Development Management
Lincolnshire County Council
County Offices
Newland
Lincoln LN1 1YL
Tel: 01522 782070
developmentmanagement@lincolnshire.gov.uk

Application Ref: H16-0692-25

Proposal: **Development of site to provide a food store and drive-thru, along with all associated works and access**

Location: **Land to the south of Holbeach Road, Spalding, Lincolnshire, PE12 6JP**

Appendix E
Traffic Flow Diagrams

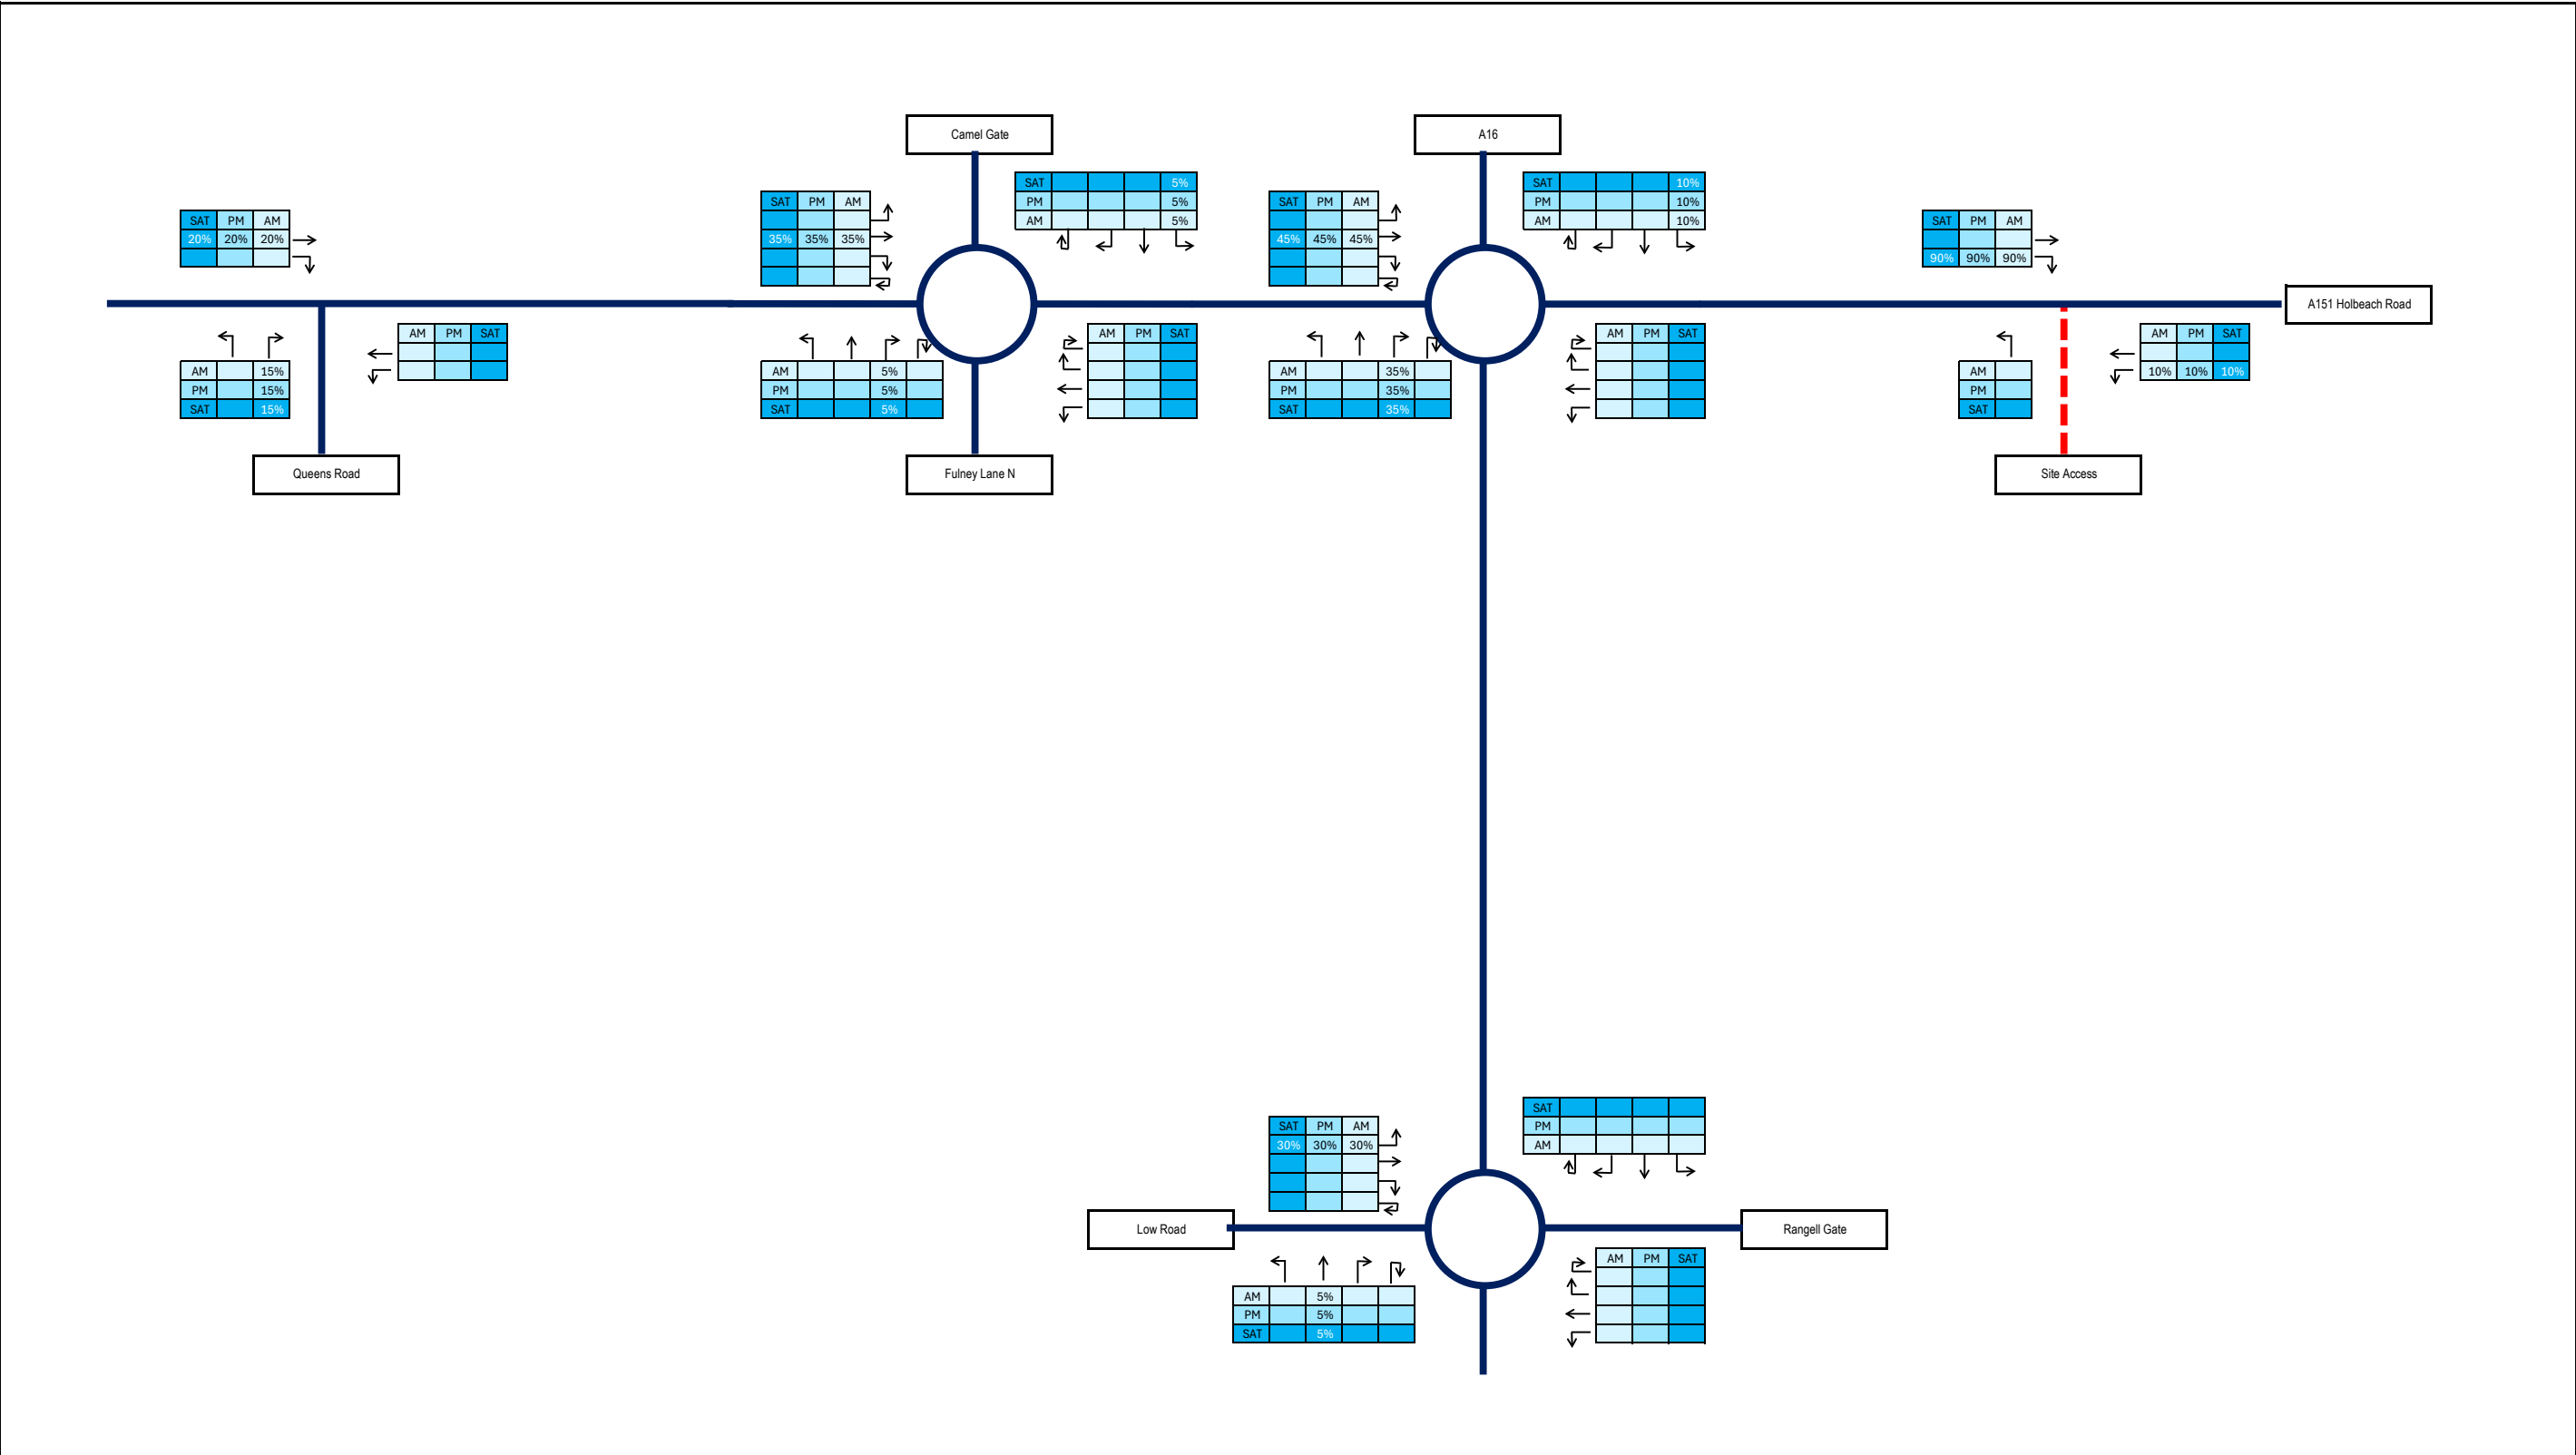
The tracking is unworkable at peak hours as HGV's will need to take up both lanes exiting the site. The swing that is needed can't be achieved on the access road without moving the stone pillars – we need security that they can be moved.

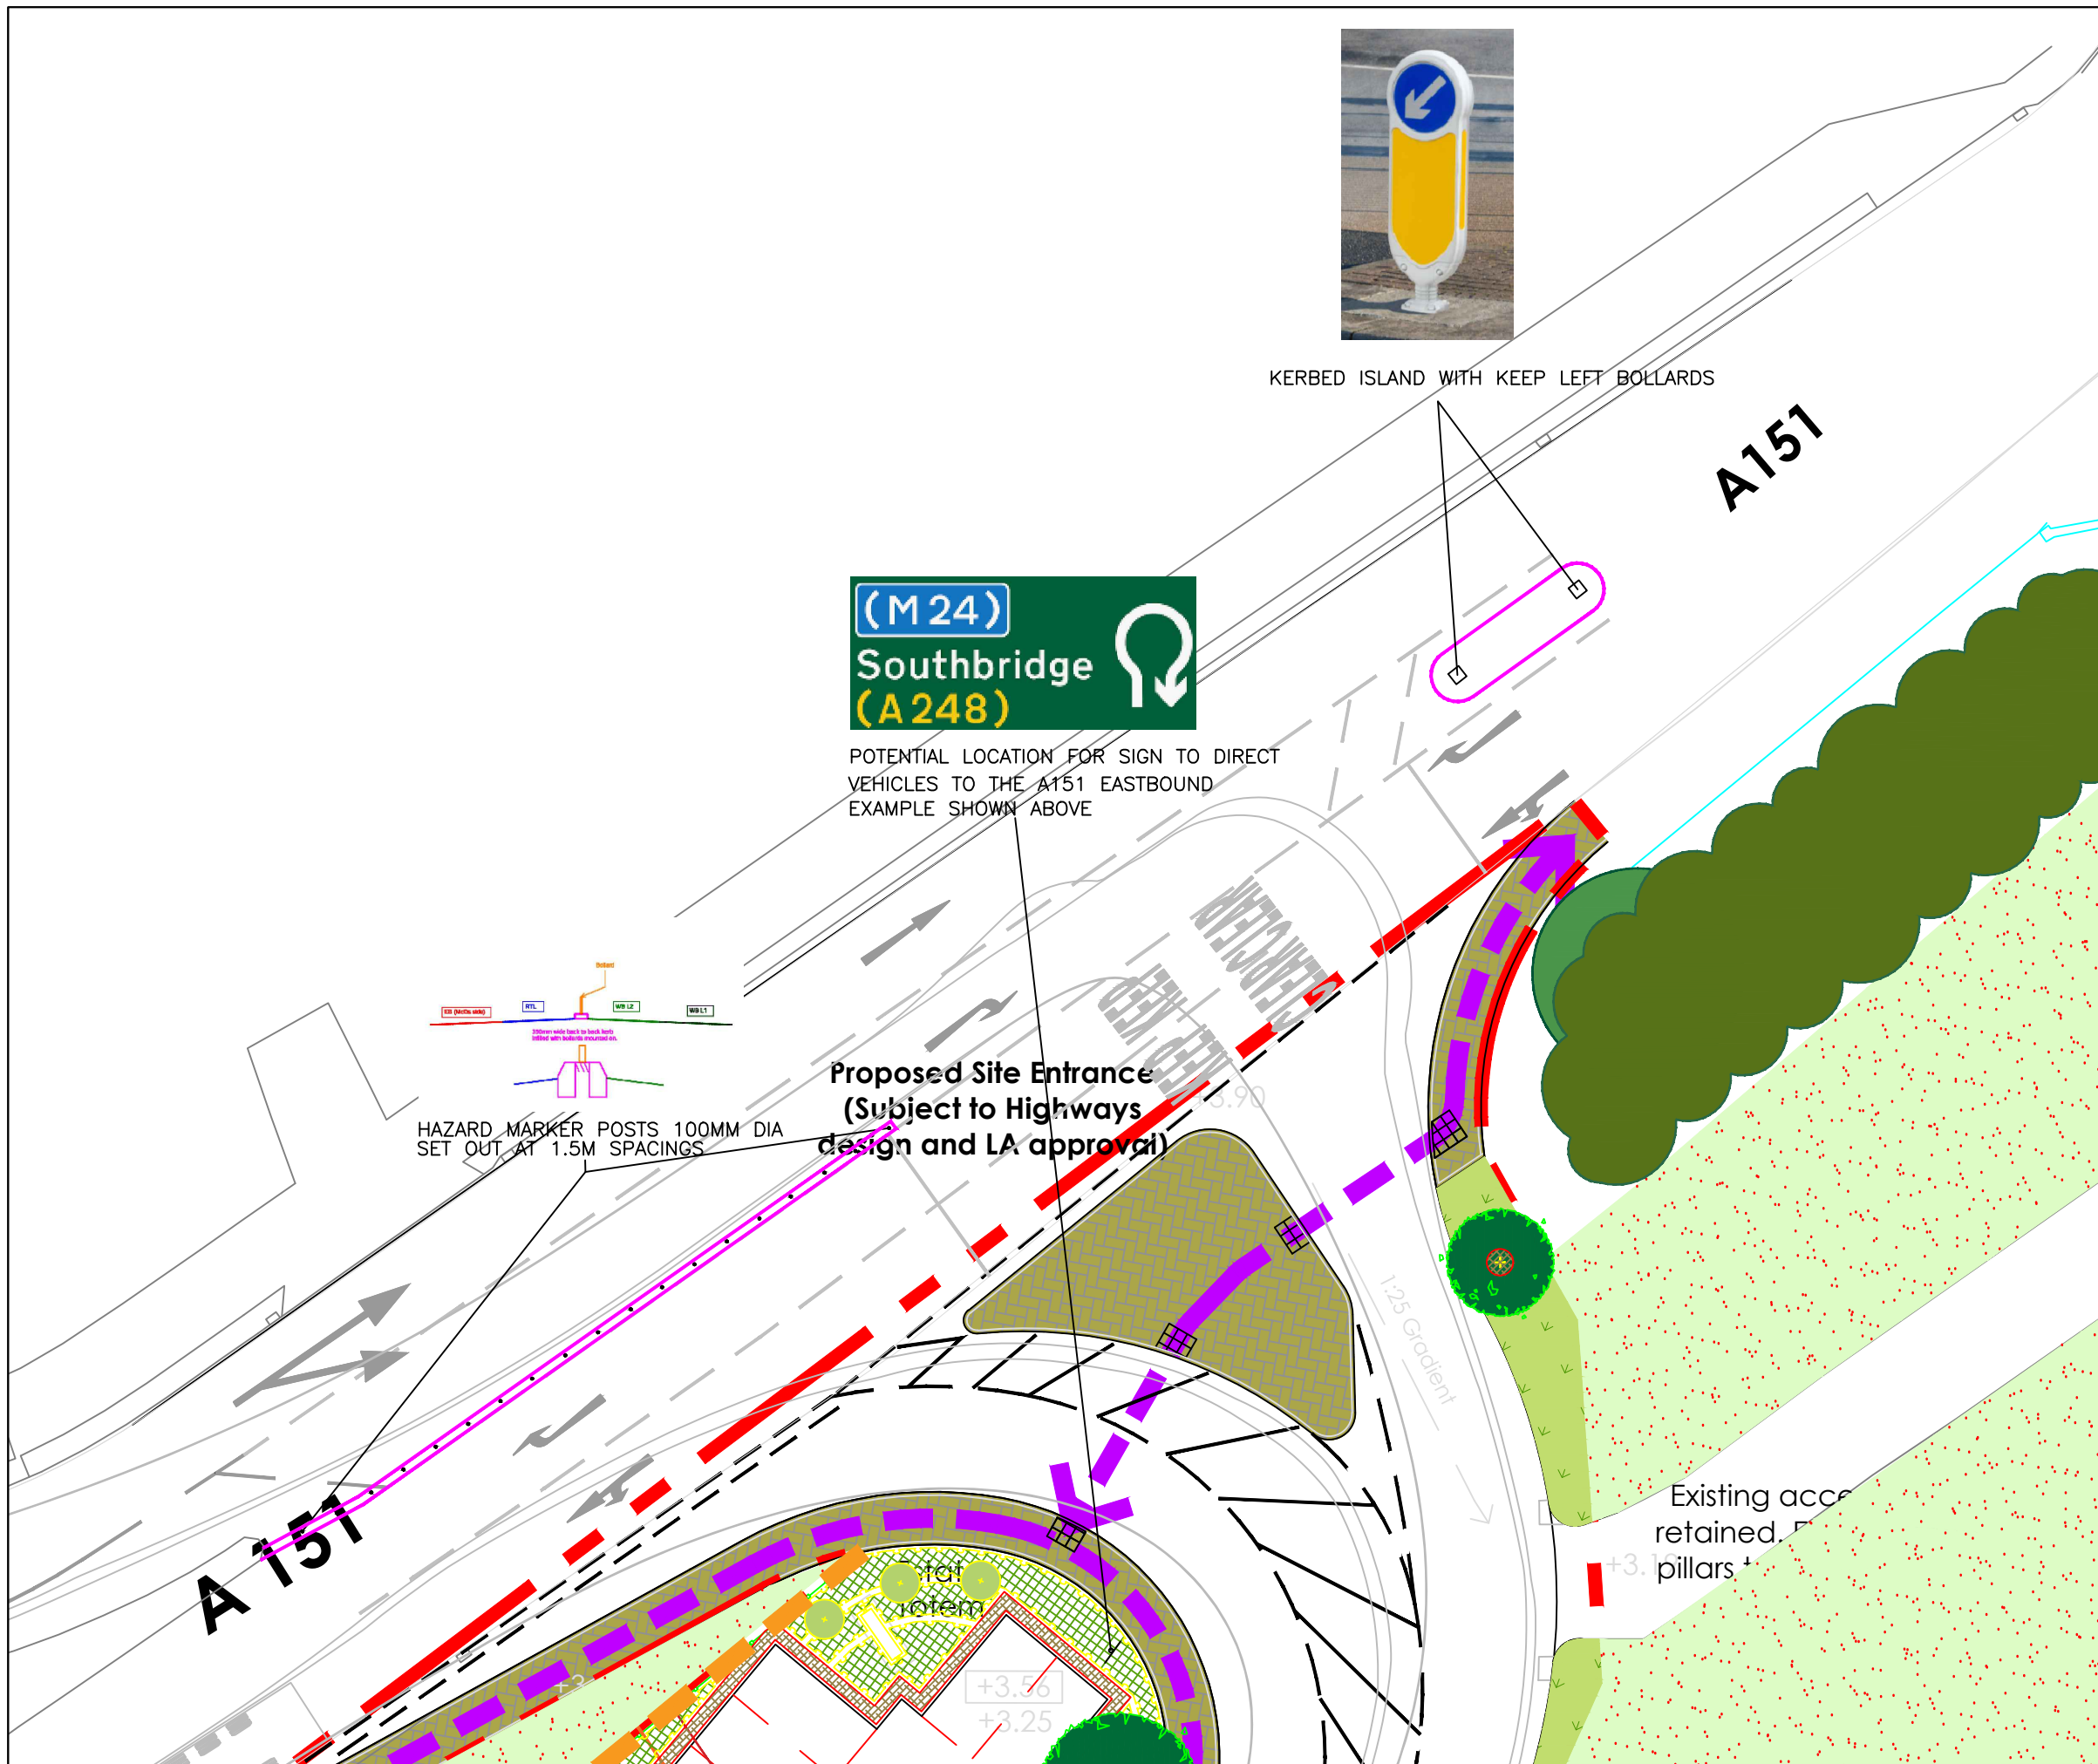
The Transport Assessment does not address safety and the accident data detailed is out of date. Concerns internally with queuing – particularly with it being a Drive Thru and how they operate. There should be a right turn lane internally to the Coffee Drive Thru so that queues internally do not back up into the highway.
